## Section 1: LADACAN's comments on the Applicant's REP8-038 submission

## Section 2: LADACAN's concerns regarding noise contour modelling

(comments apply to Applicant's REP6-063 response to NO.1.11 and to REP8-038 Table 2.14, ID 3, p58)

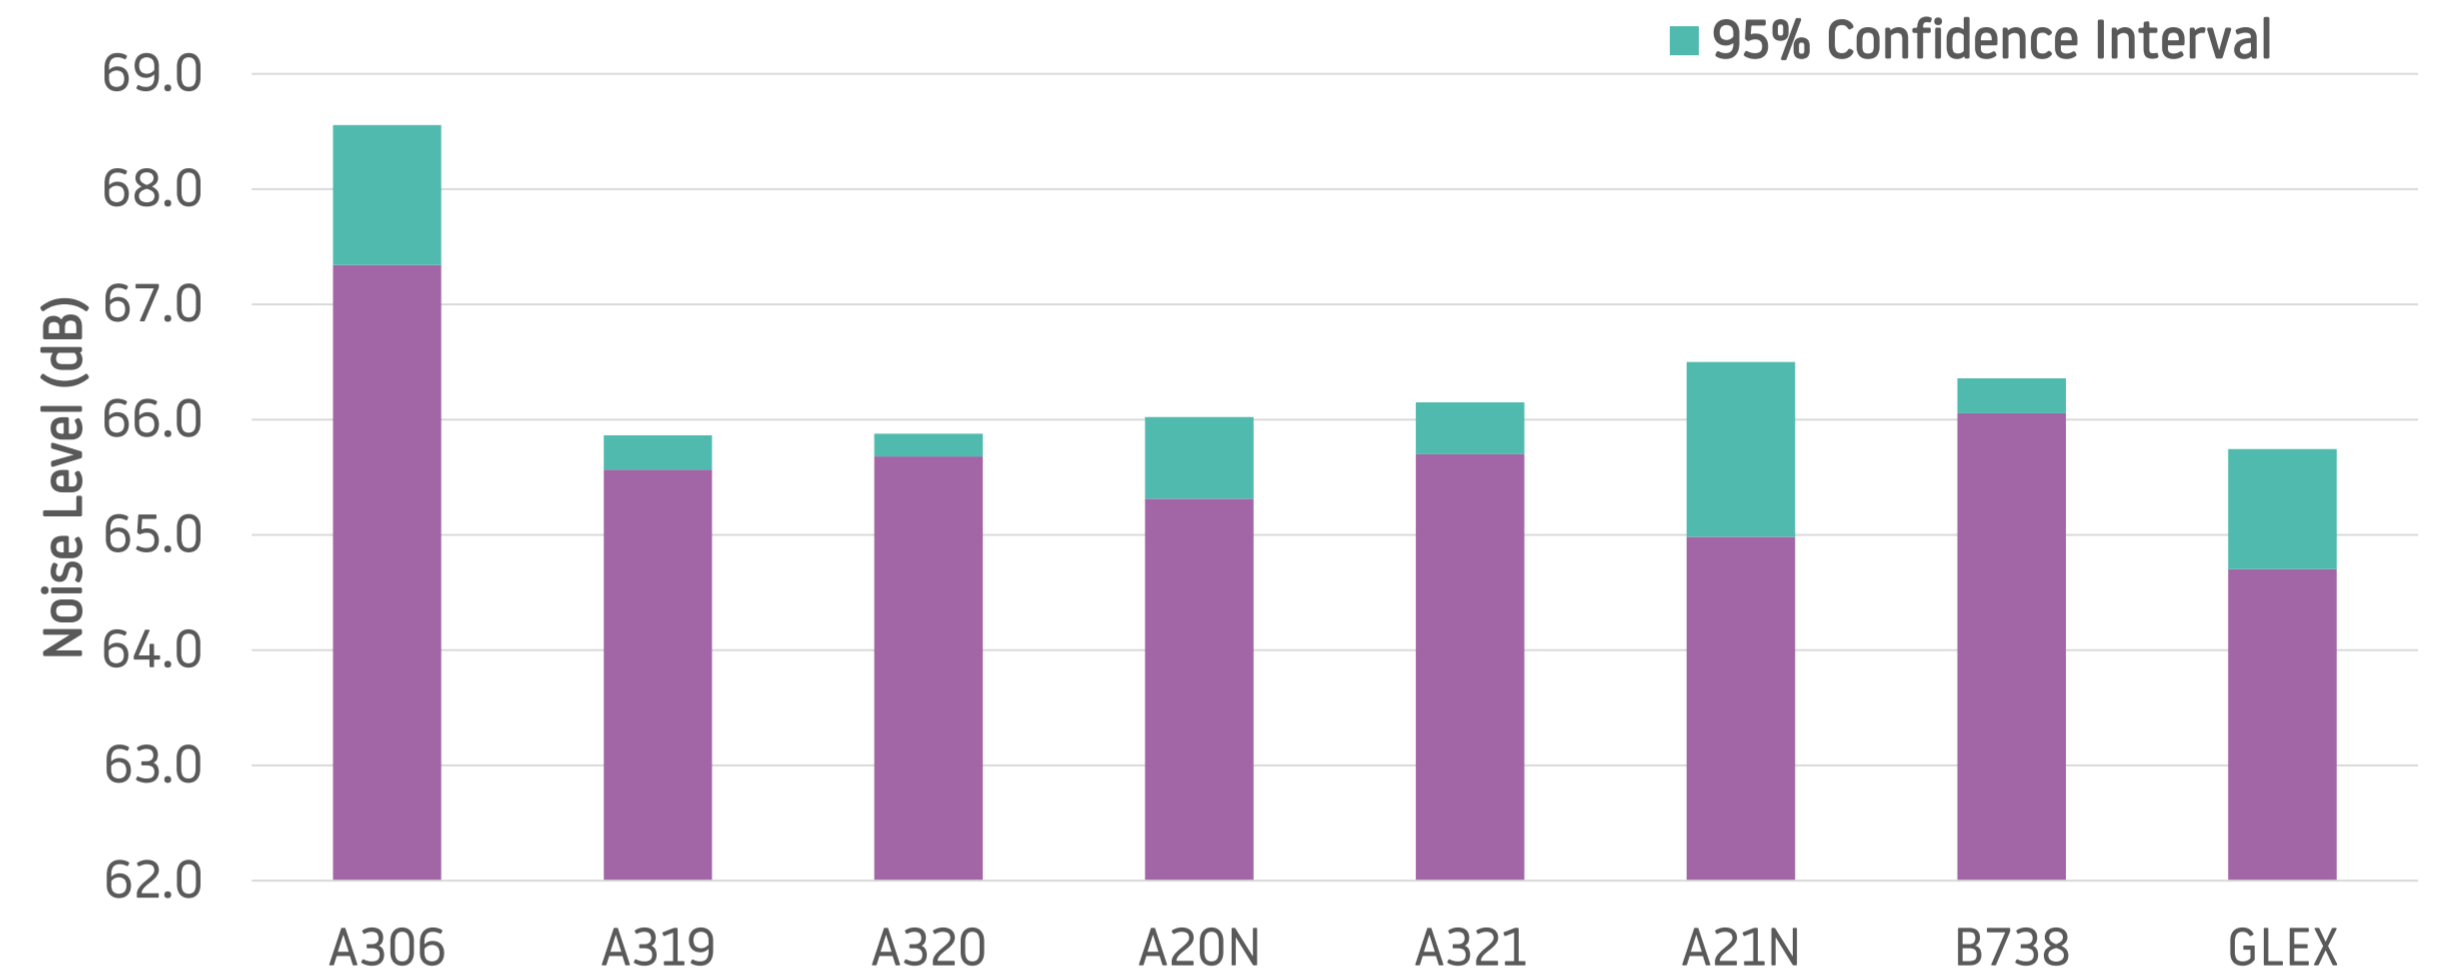
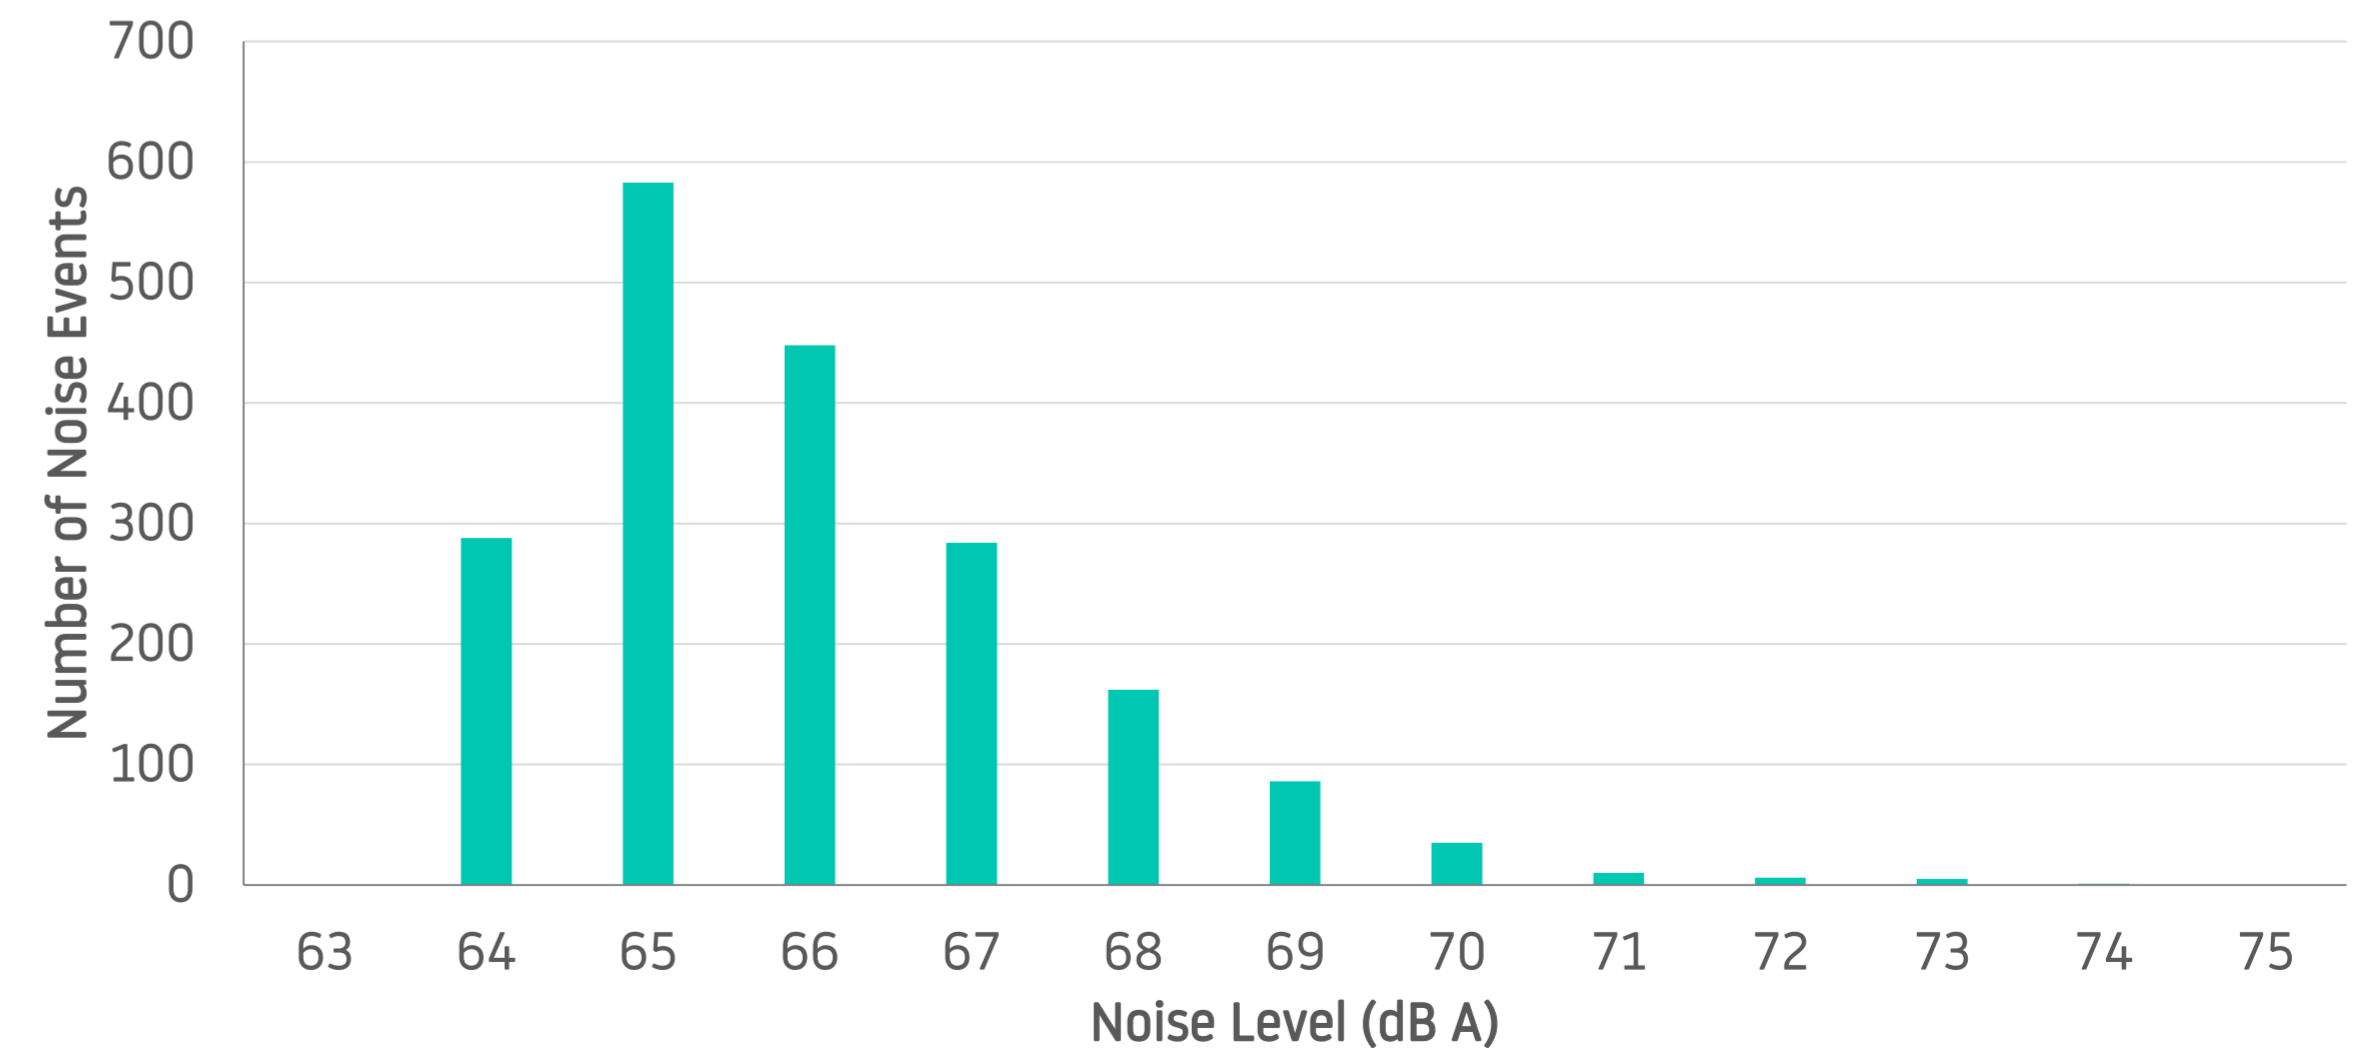
- d) The 2019 CNR data for Dagnall (used by the Applicant) shows a similar issue, with an apparent cutoff below 64dB and yet aircraft LASmax averages between 65.2 and 68dB.
